# KITTITAS COUNTY

### MEMORANDUM

**TO:** All Staff  
**FROM:** Public Works Plan Review Team  
**DATE:** December 10, 2024  
**SUBJECT:** SPF-24-00012 Sparks

BOWERS ROAD SHORT PLAT
PART OF SECTION 26, T. 18 N., R. 18 E., W.M.
KITTITAS COUNTY, WASHINGTON

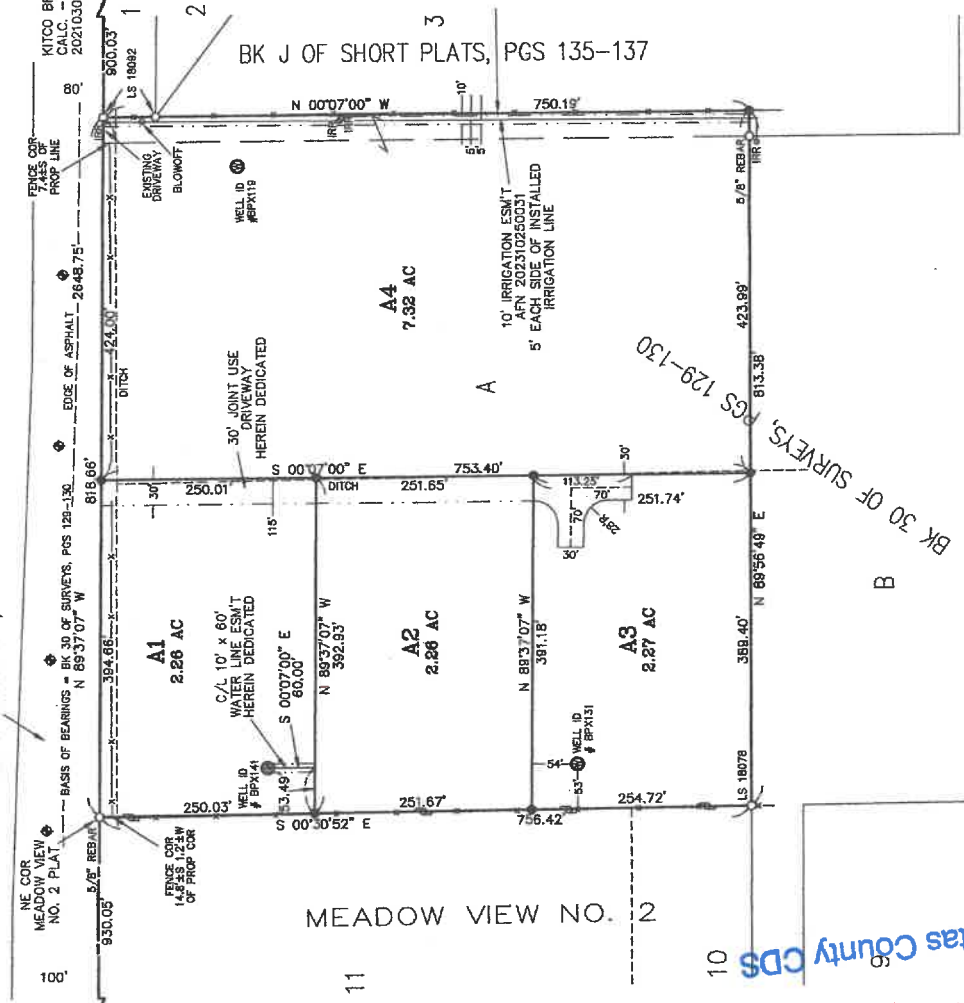
| <b>SURVEY</b>                     | <ol style="list-style-type: none"><li>1. Please clarify the purpose of the "115' "notation located near the SE corner of lot A1. (JT)</li></ol>  |
